1419/P03 A

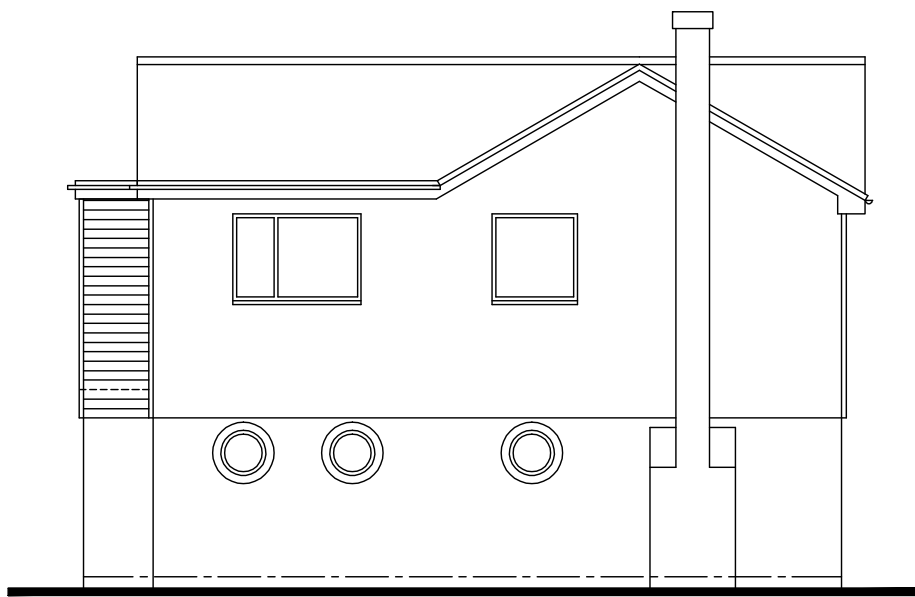
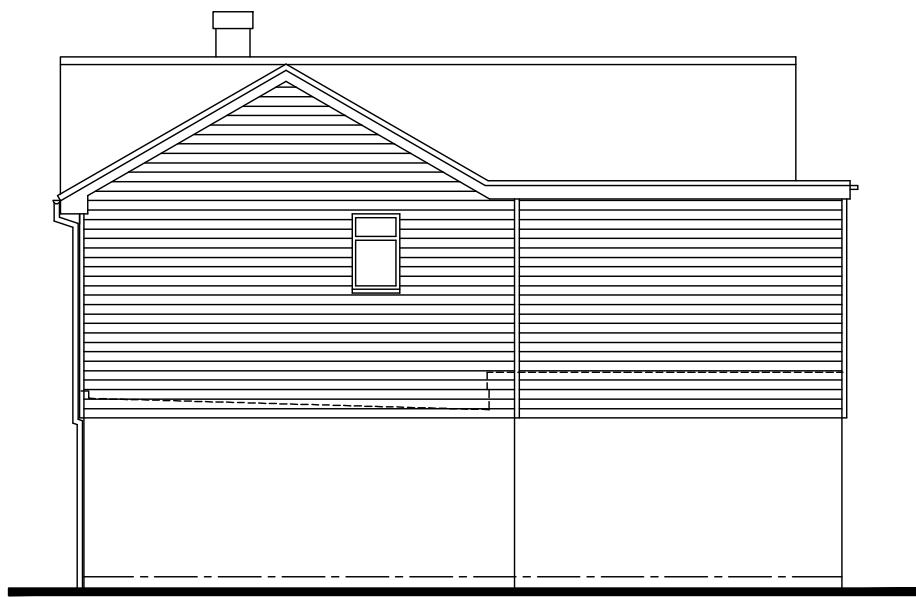
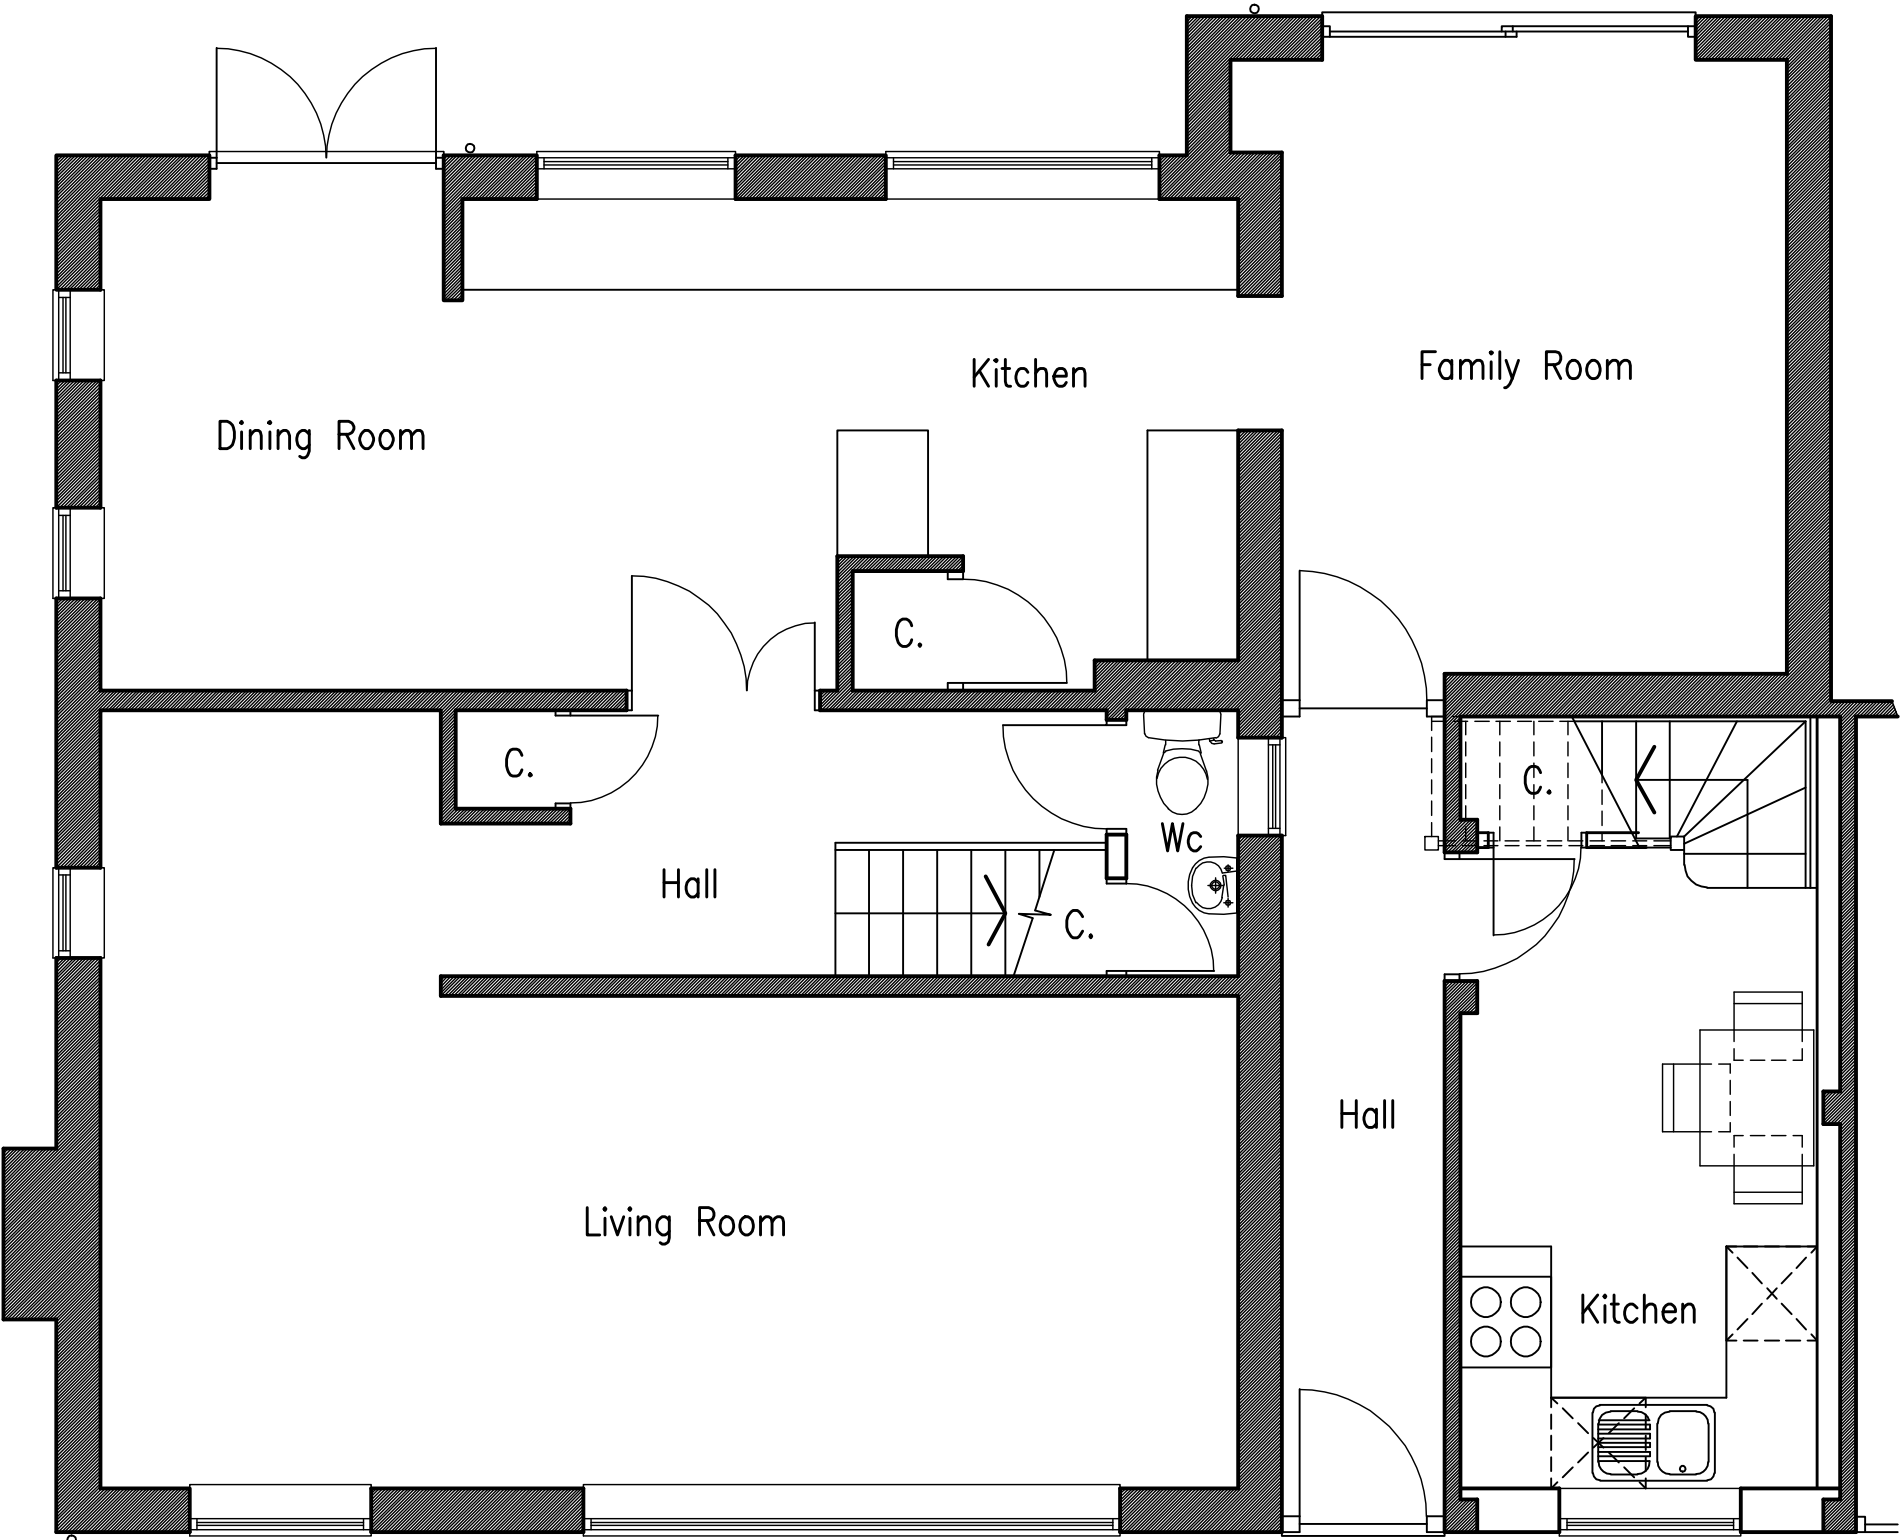
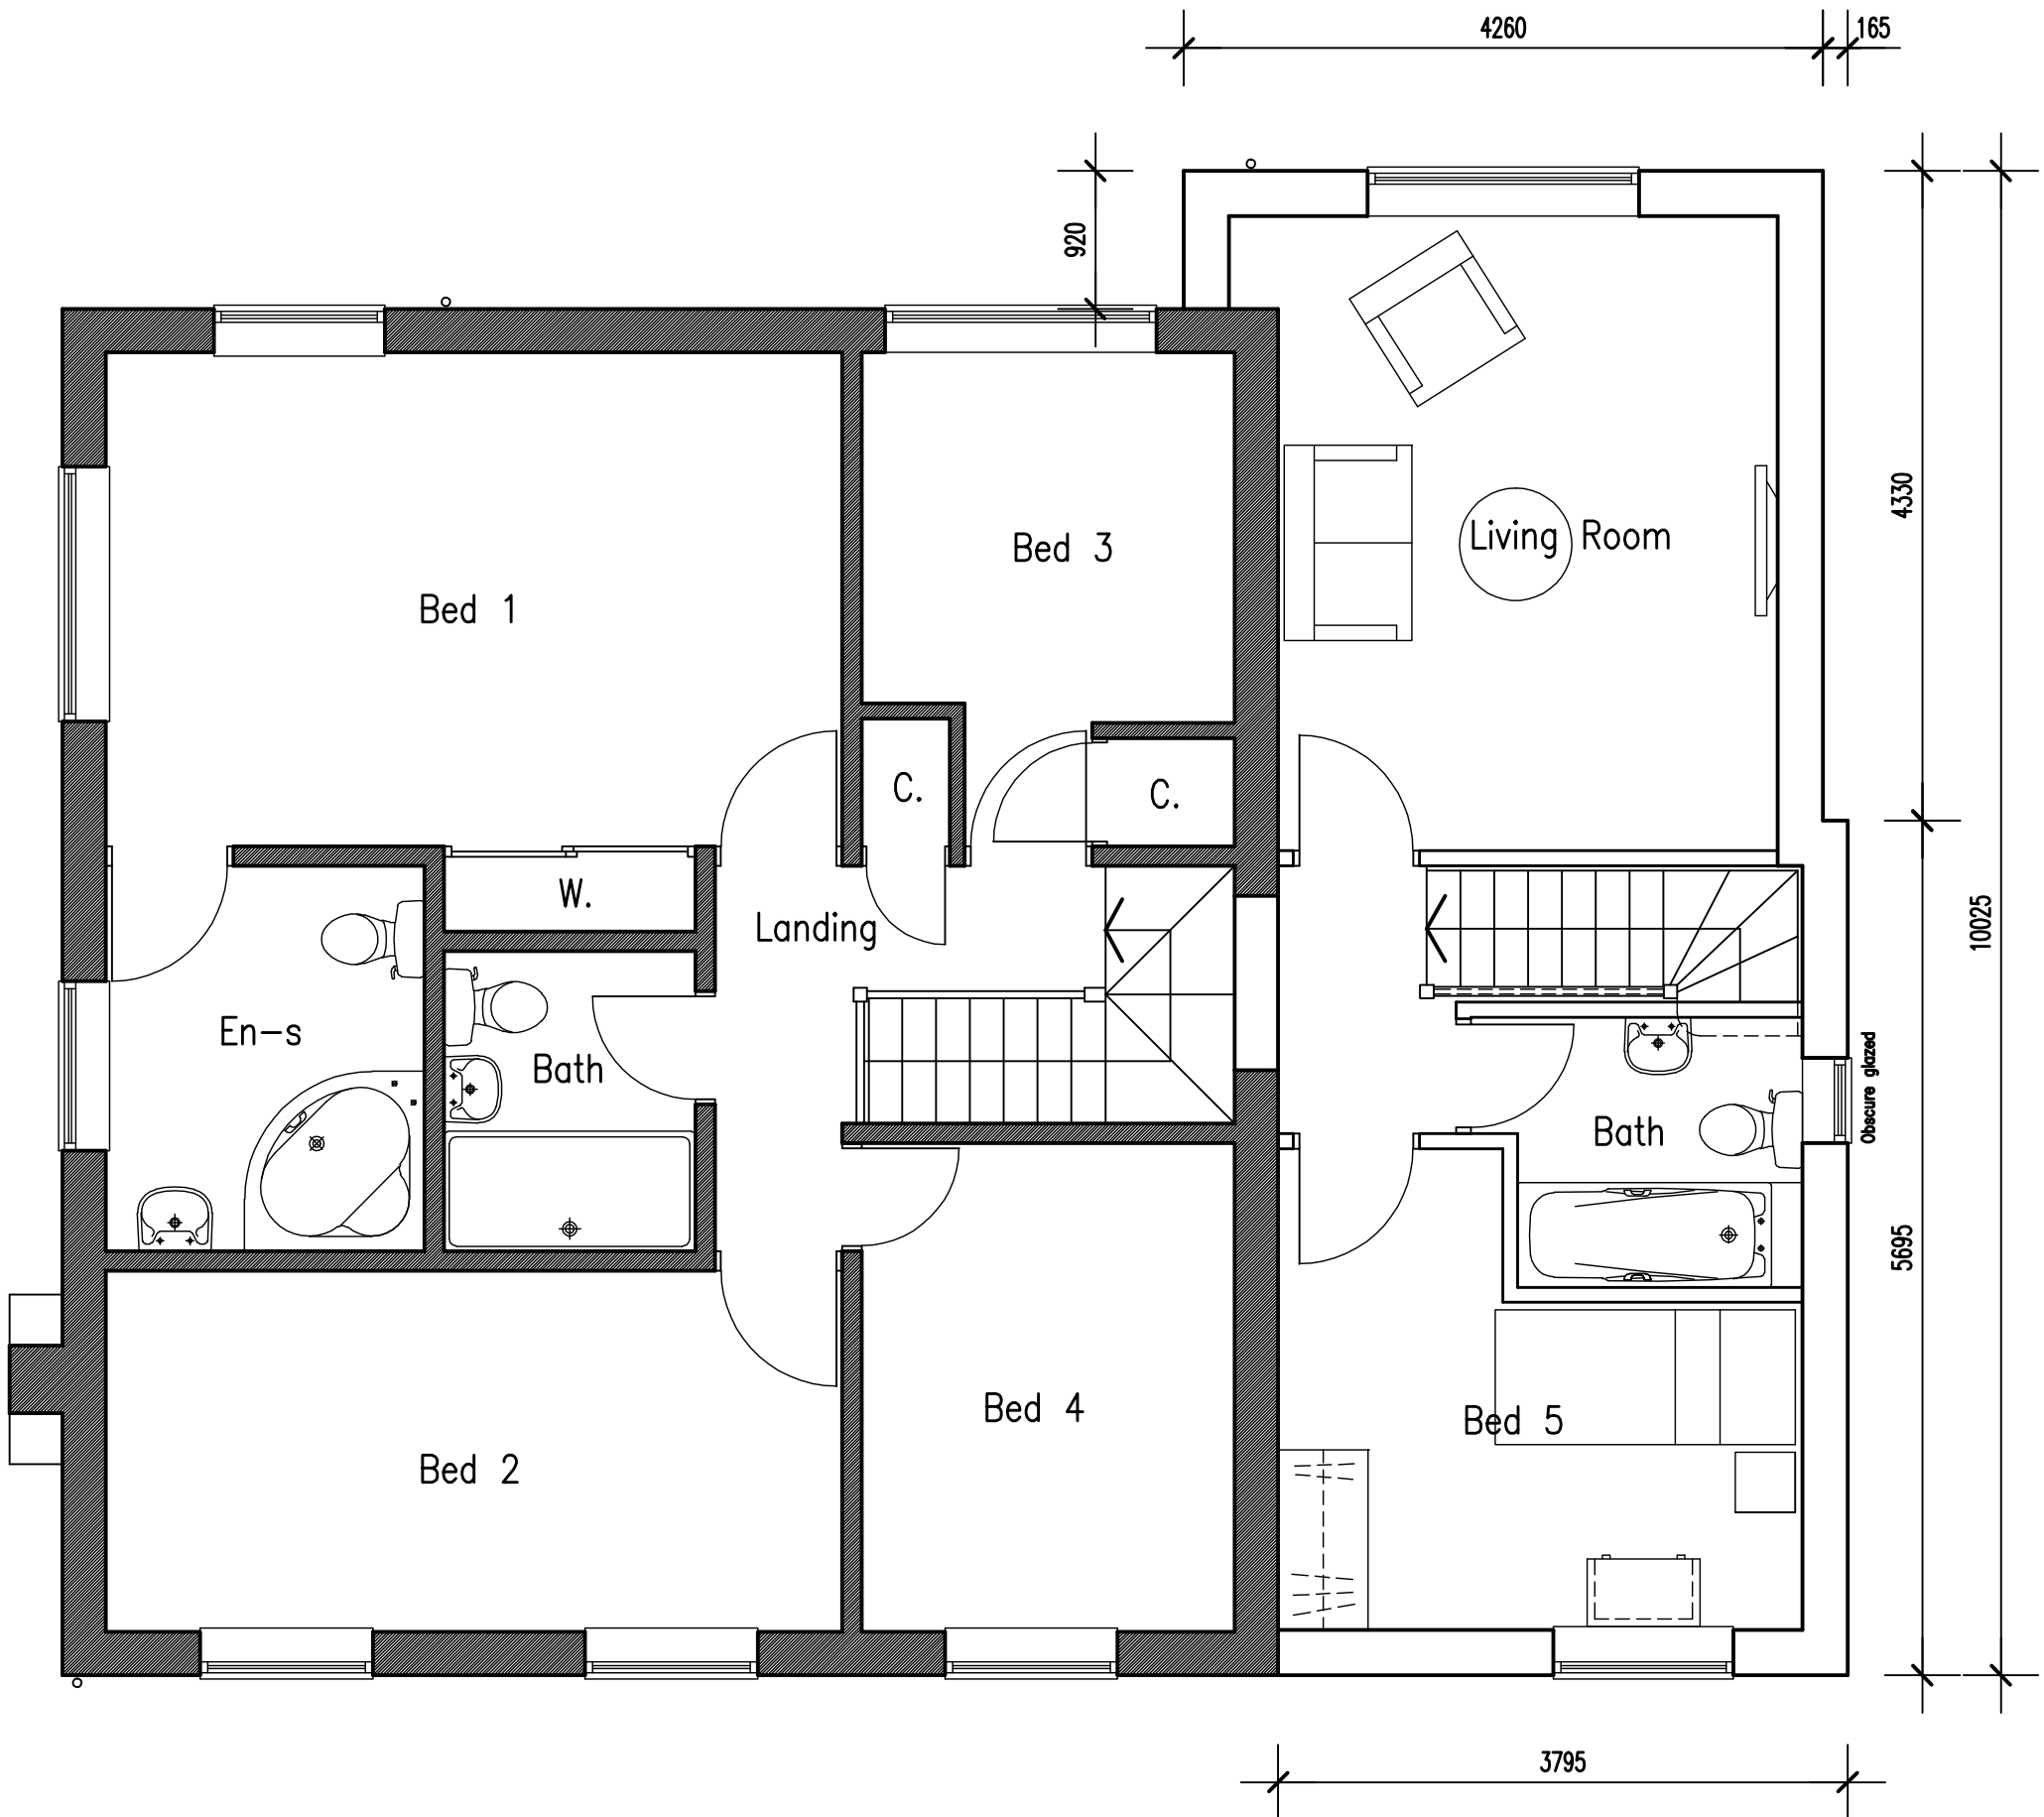
Having spoken to my manager would it be possible to move the proposed frontage of the extension back 0.5m to avoid the possibility of terracing if number 32 decides to do the same? If this is something you can do please send amended drawings so that I can get a decision with you as soon as possible.

Further to your earlier e-mail please find attached amended drawings showing the first floor extension set back by 500mm as requested.
